**From:** [REDACTED] >  
**Sent:** 14 March 2025 09:58  
**To:** XLinks  
**Cc:** [REDACTED] point-notification.espool (RWS WVL)  
**Subject:** Response Netherlands to Xlinks Morocco-UK Power Project

Thank you for the opportunity to react on Xlinks Morocco-UK Power Project, following the letter dated 31 January 2025 with reference number EN010164. Please find below the response from the Netherlands. We would welcome the opportunity to stay involved in the remainder of the process on a regular basis.

Drawing Title
DOCUMENT 2.3.2 OFFSHORE WORKS PLANS SHEET 1 OF 2

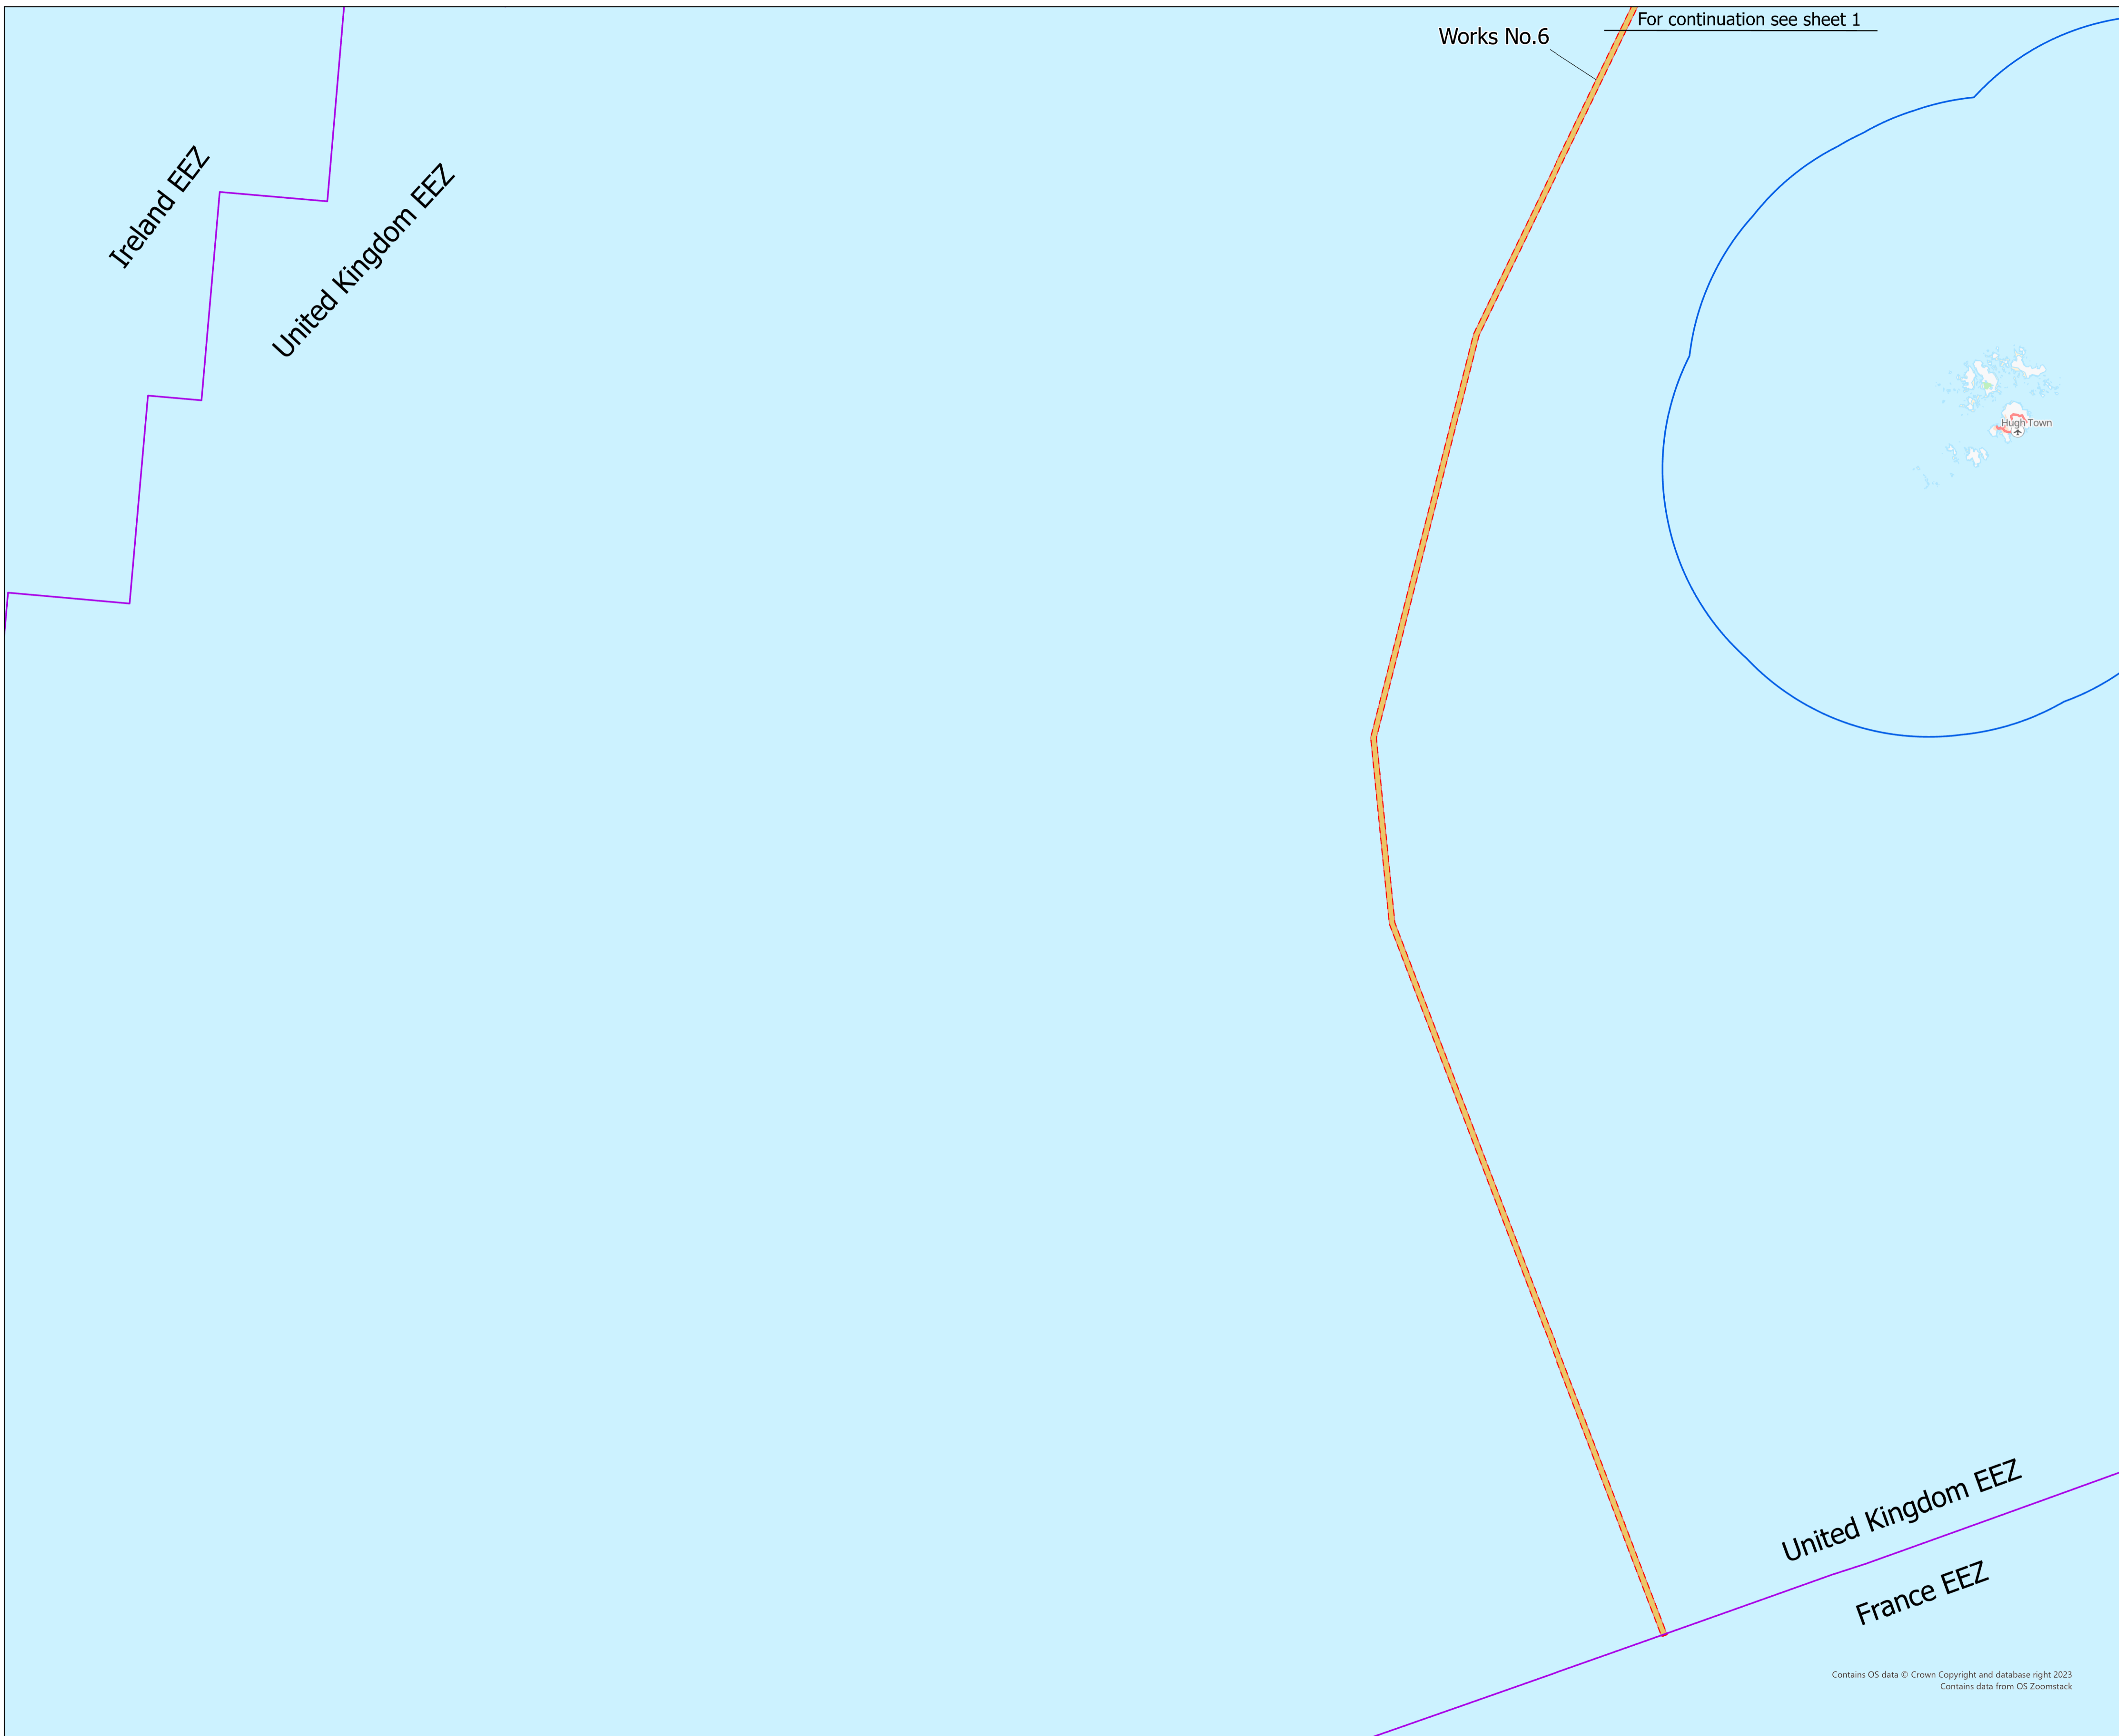
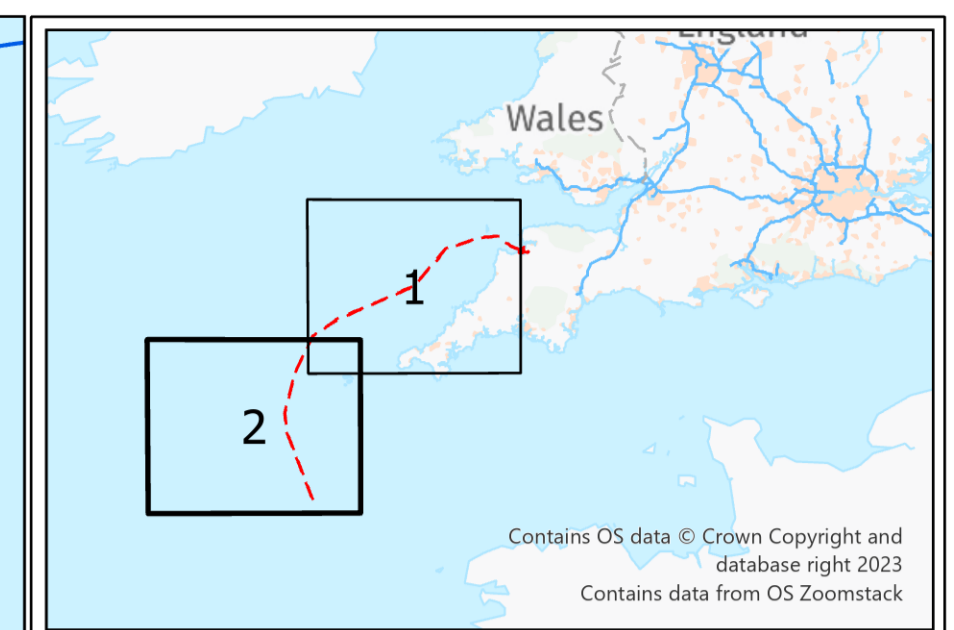
Cables emit electromagnetic fields and potentially have an impact on migratory fish and elasmobranch species. The exact impact is not fully understood, but it is recommended to take this into account. Please consider international collaboration on this aspect. The Netherlands has also published research, please find this on: <https://open.rijkswaterstaat.nl/@180353/current-state-knowledge-electromagnetic/>

Moreover, effects of electromagnetic fields will be present throughout the duration of the project, not temporary, as claimed in the EIA.

The environmental impact assessment only seems to cover the part of the electricity cable to be installed in UK waters, whilst it is the full length of the cable across the Channel that creates possible negative transboundary effects for migratory fish and elasmobranch species. If possible, the Netherlands is curious to know whether an environmental impact assessment has been done for the entire scale of the proposed development. If so, we are eager to receive this information.
